Planning Officer: Raymond Cole

Planning Application Ref: P/132/20/RES

Location: Land north of Hook Lane, Pagham

Description of works: Approval of reserved matters following P/30/19/OUT for 300 No. new homes, internal roads, footpaths & cycleways, car parking & landscaping. This application affects the setting of a listed building & falls within Strategic Site H SP2, CIL Zone 1 (Zero Rated)

Project	Hook Lane, Pagham
Drawing	Site Layout
Client	Hallam Land
Job no.	HALL200505
Dwg no.	SL01
Author	AS
Status	PLANNING
Client ref.	
Date	June 2020
Revision	A
Scale	1:1000 at A1
Office	Romsey

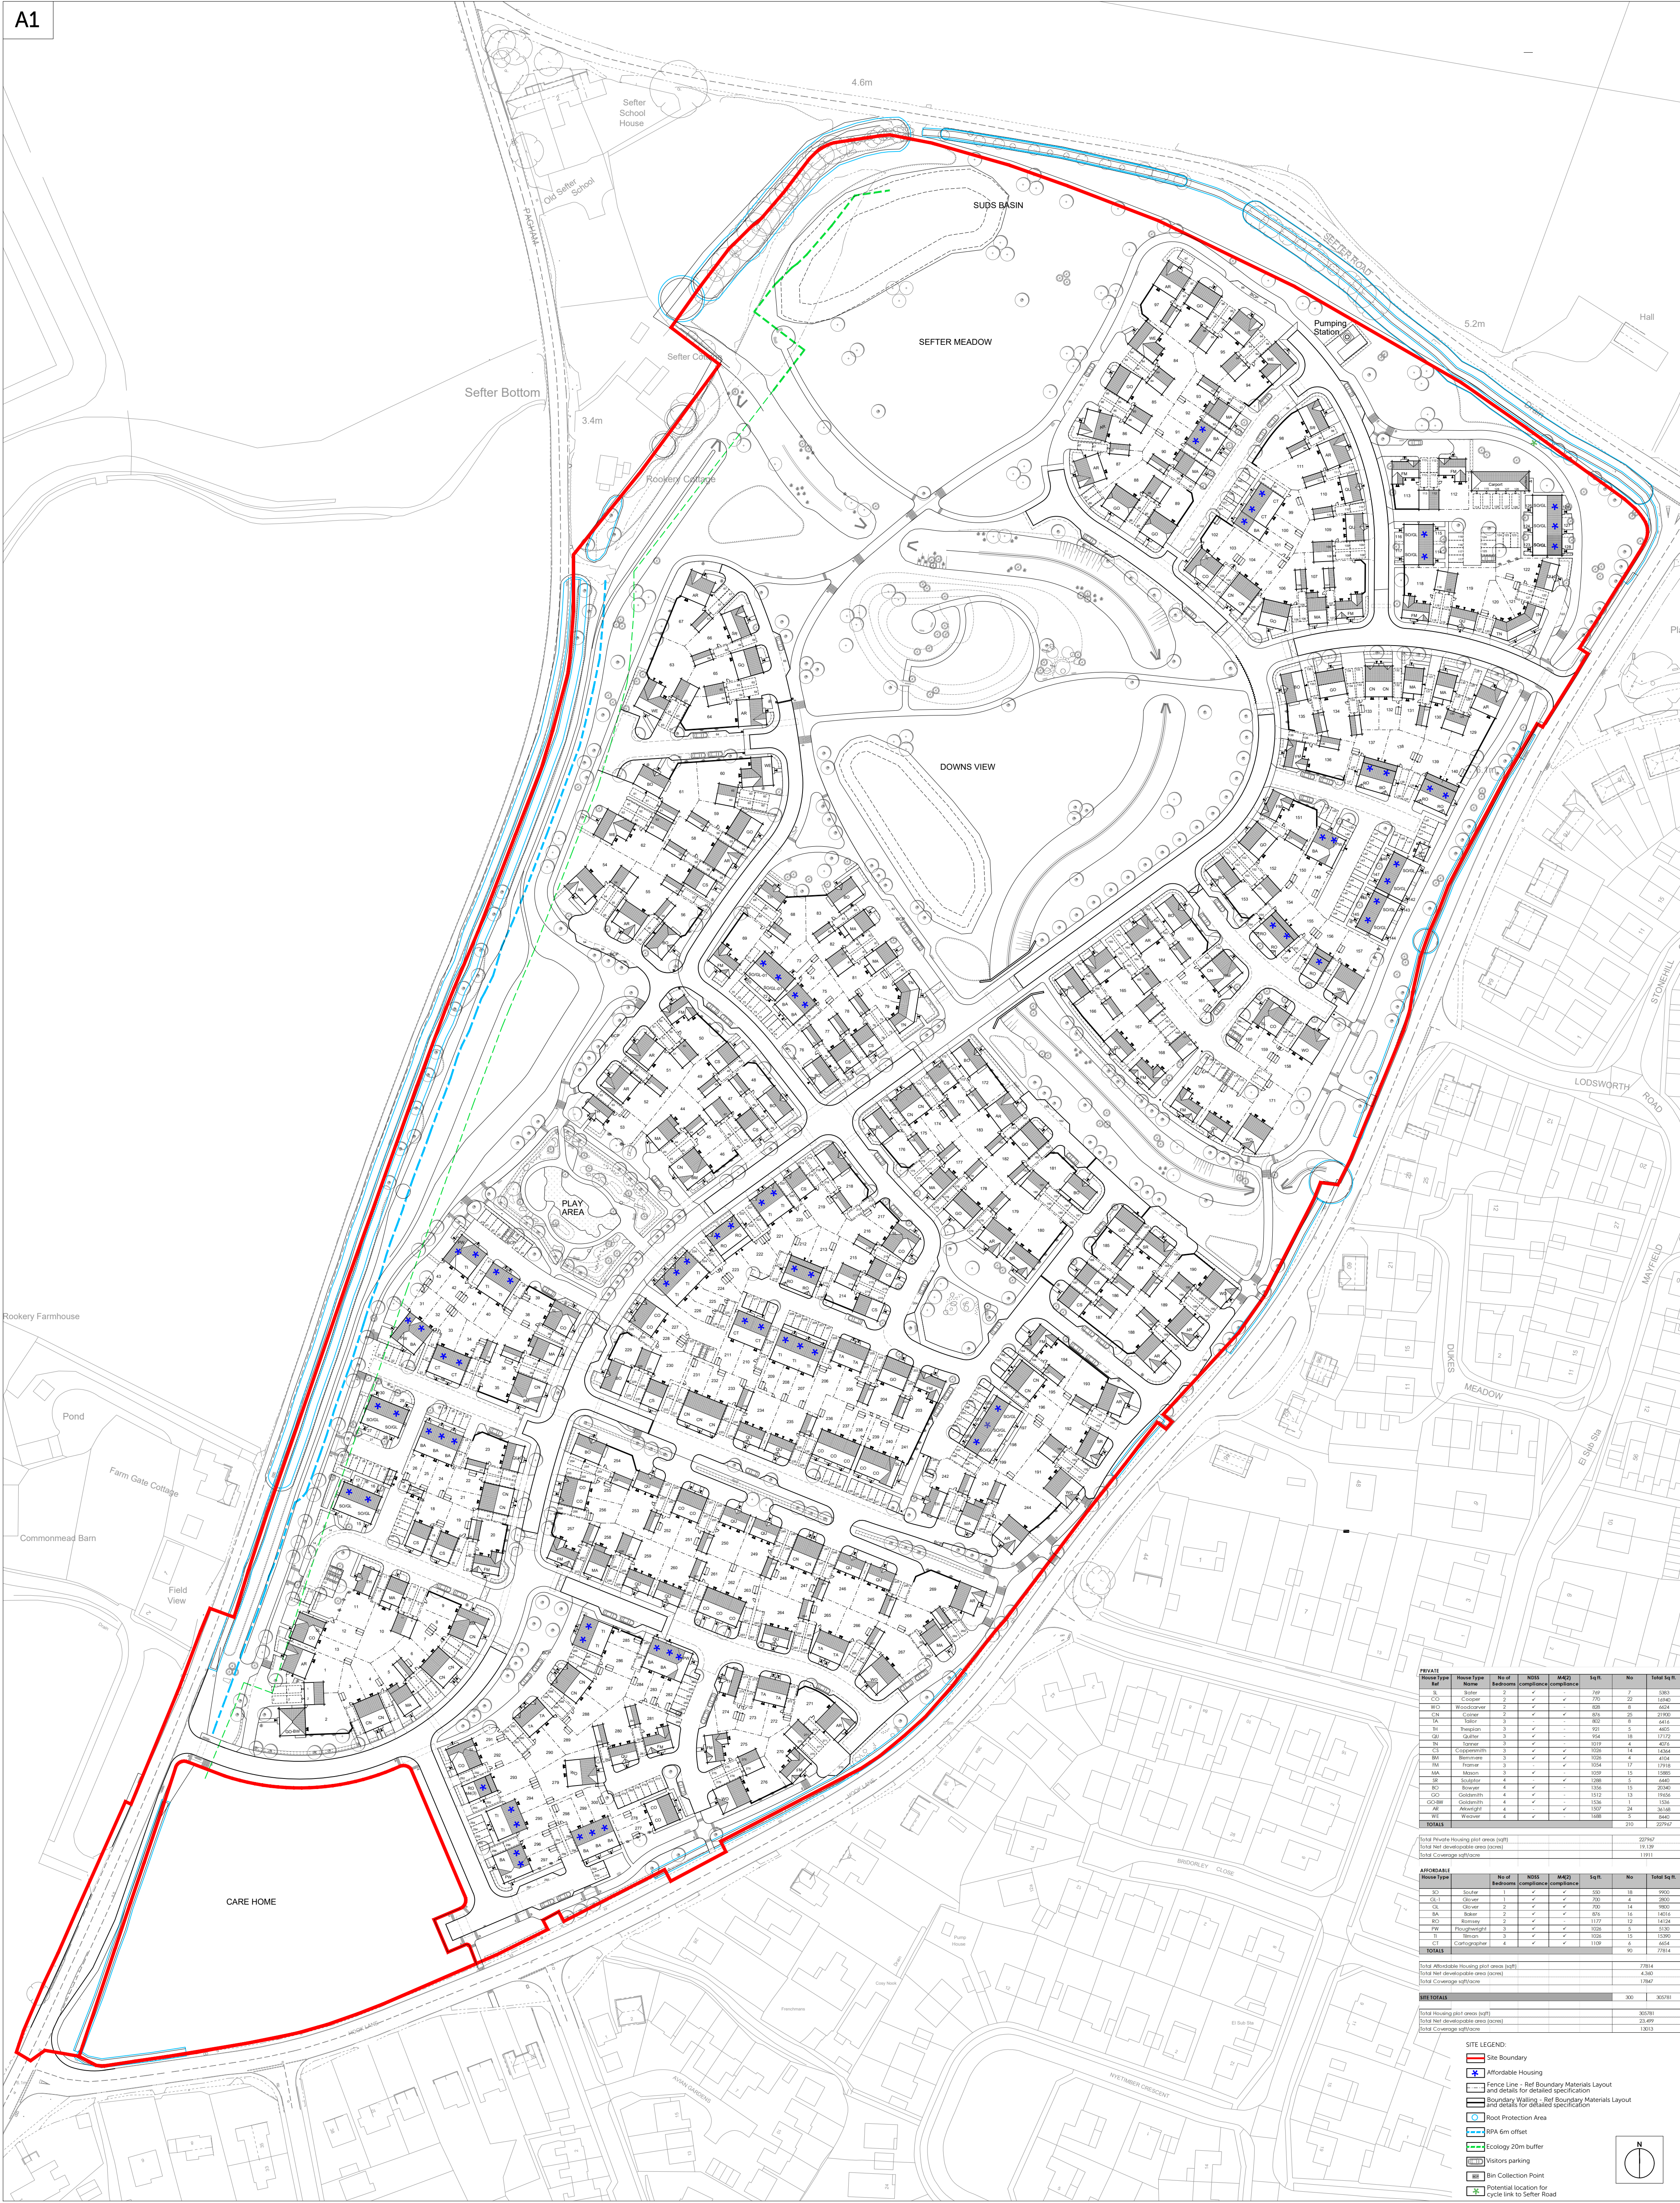
- With relatively few trees across the site (significant perimeter hedgerows aside) there are few opportunities for conflict between trees and any construction. Those trees to be retained have been afforded sufficient room to allow future growth without significant constraint, although we must await the final drainage strategy (LPA approved) before a comprehensive understanding of tree retention/protection is reached. It is encouraging at this stage to see H2 and G3 afforded ample room to flourish – potentially important screening between developments.

- I draw attention to the nominal root protection areas (RPA) of retained trees and their growth potential as obvious constraints to the siting of any SUDS (e.g. swale or attenuation pond) or introduction of subterranean utility apparatus. The provision of appropriate buffer/easement around such features must also take into account that growth potential (roots), to limit the risk of damage occurring during future maintenance of the same, from compaction/contamination of the soil structure.

- The proposed layout, so far as it is described and in general terms, is certainly achievable without undue detriment to retained trees and hedgerow although important information is lacking (see below).
- In the absence of an approved surface water Drainage Strategy I remain concerned for the potential impact on such vegetation, so must register an Objection – although expect that to be easily overcome with a sympathetic design showing harmonious relationships between existing RPAs/future growth potential and appropriately buffered SUDS features.

- As it stands, I am unable to support the site layout and so register an **OBJECTION**.
